DELEGATED DECISION TO DETERMINE APPLICATIONS FOR LISTED BUILDING CONSENT

Reference No:	2024/65/91050/E
Site Address:	Al Hashim Academy, Cambridge Street, Batley, WF17 5JH
Description:	Listed Building Consent for installation of solar panels to roof
Recommending Officer:	Sebastian Pickles

DECISION – CONSENT GRANTED

DRAWING TITLE- MODULE LAYOUT

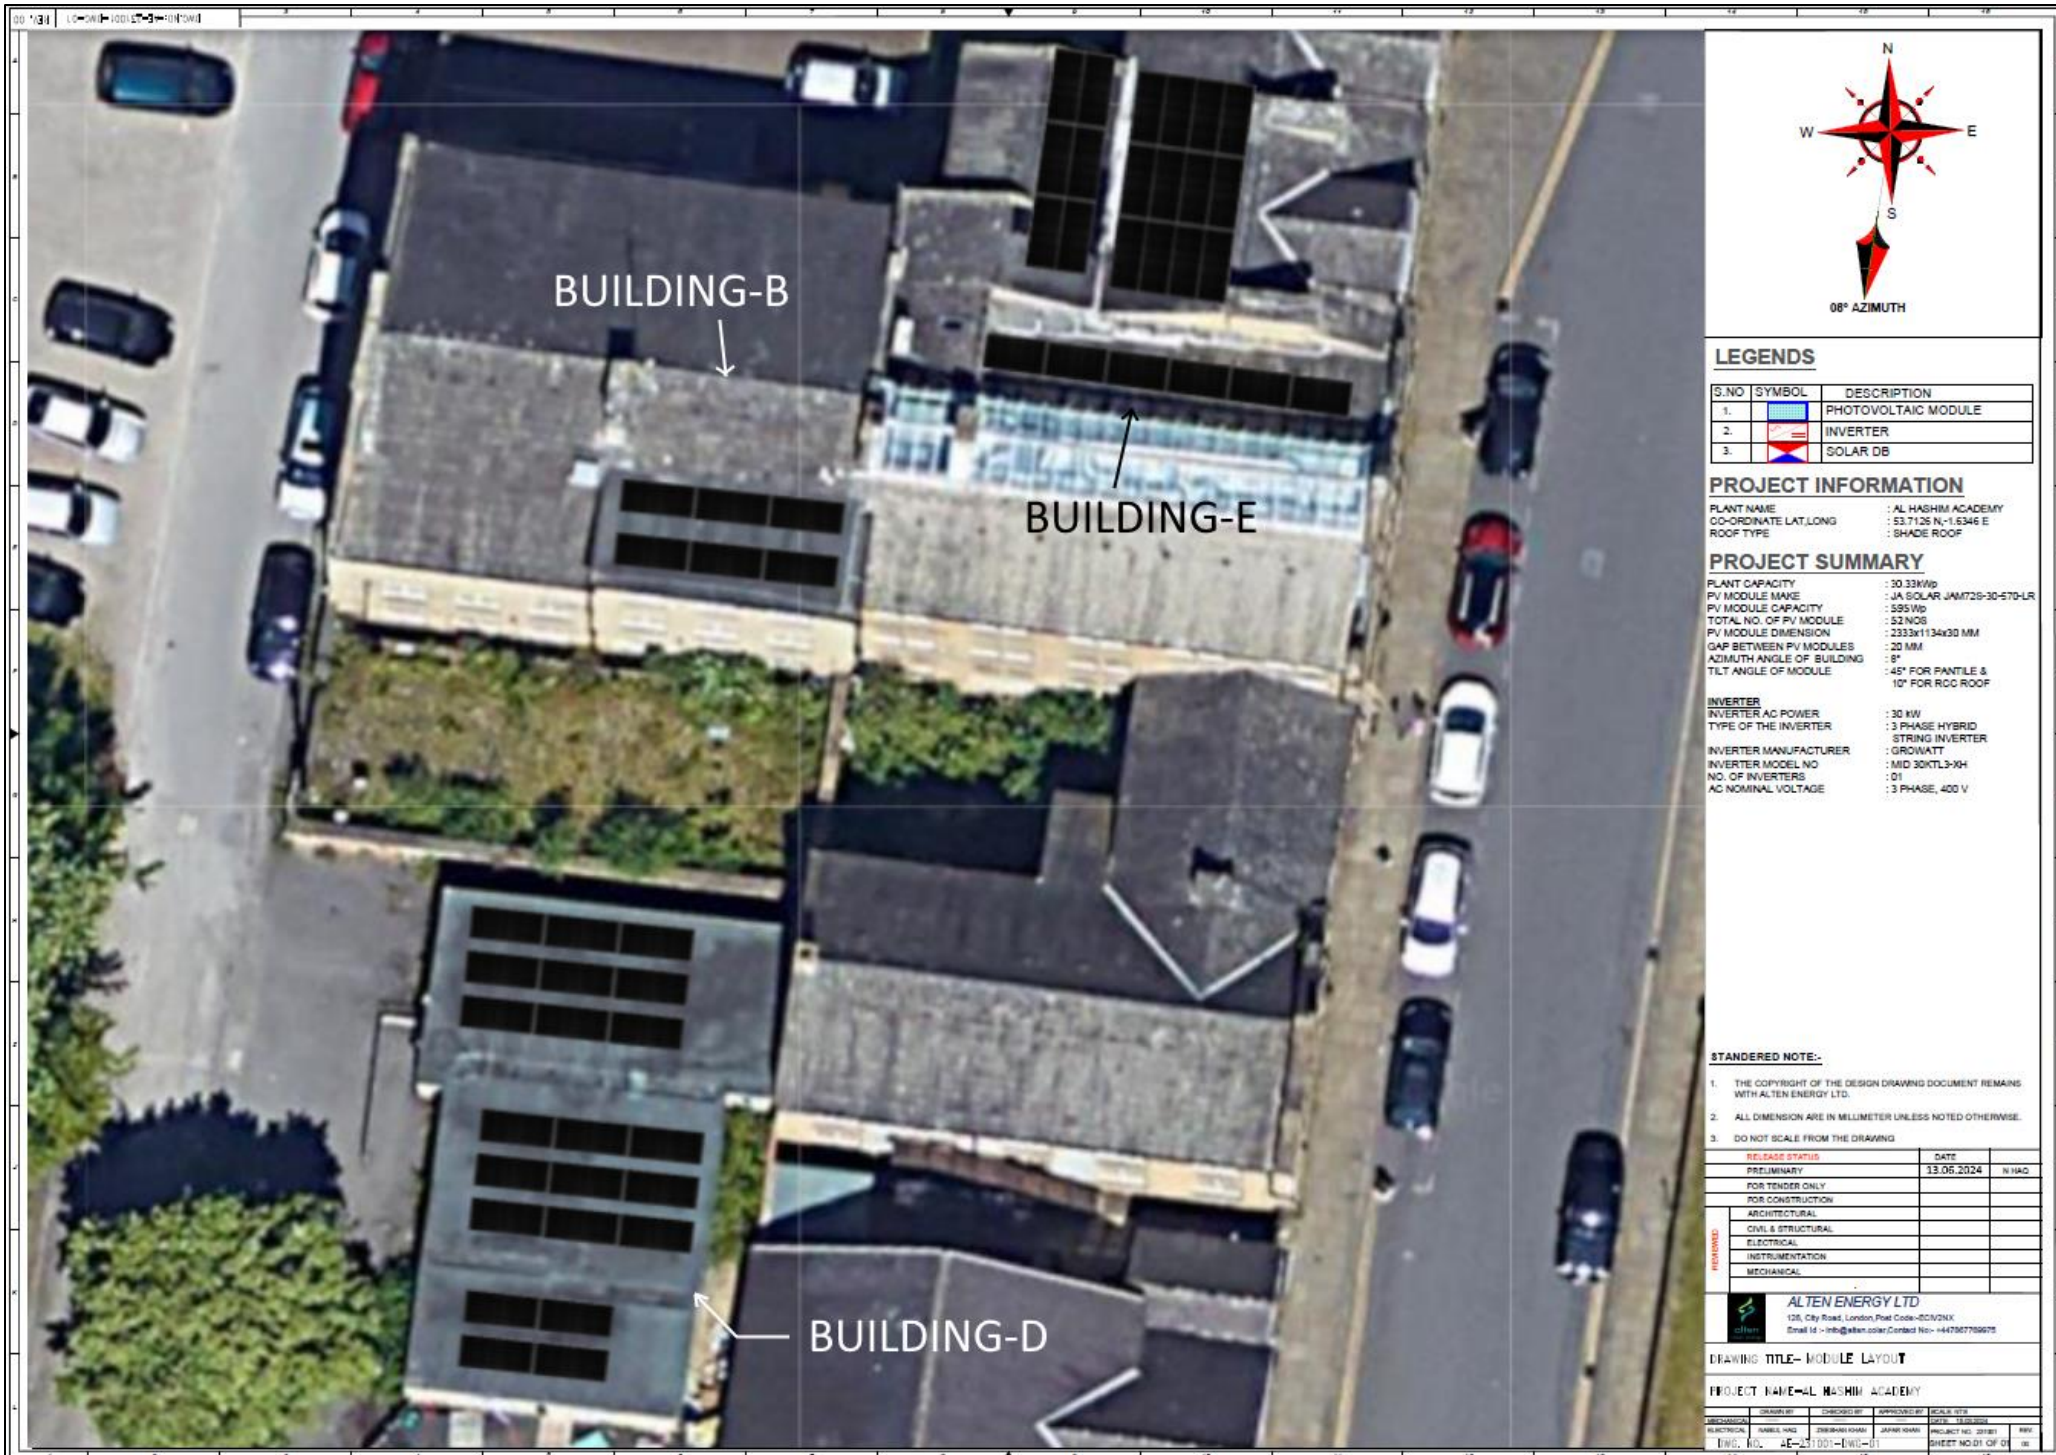
The initial proposals were for panels on the majority of the roofs for buildings. Comments were provided to the agent/ applicant setting out that the number and placement of panels could not be supported as the impact on the Listed Building was unacceptable and there was insufficient demonstrated benefit to outweigh the harm.

The revised scheme will have panels placed on roof planes which cannot be viewed or experienced from ground level due to the pitch of the roofs and parapet balconies providing some visual mitigation.

The panels to the section of roof E have been placed within the roof valleys and due to the raised parapet and pitch of the roofs, there will be no views of the panels.

There will be some glimpsed views of the panels to the flat roof section on roof B, however, it has been confirmed by the applicant that the panels will sit flat to the roof plane and therefore the impact will be negligible.

There are a large number of panels proposed to the roof of building D. While this is the case, the number of panels has been reduced from the original proposal. It has been confirmed by the agent that the panels to the roof will sit flat to the roof line, with no degree of angle and this will be conditioned to ensure compliance. While there will be a degree of impact with the panels on the roof of Building D, this will be reduced with them sitting flat on the roof and they will only be able to be experienced within the immediate area. Given the building is of more recent construction the impact is considered to be acceptable.

3. Notwithstanding the submitted details, the solar panels to roofs B and D shall be fixed so that they sit entirely flat to the roof plane with no angle of projection permitted.
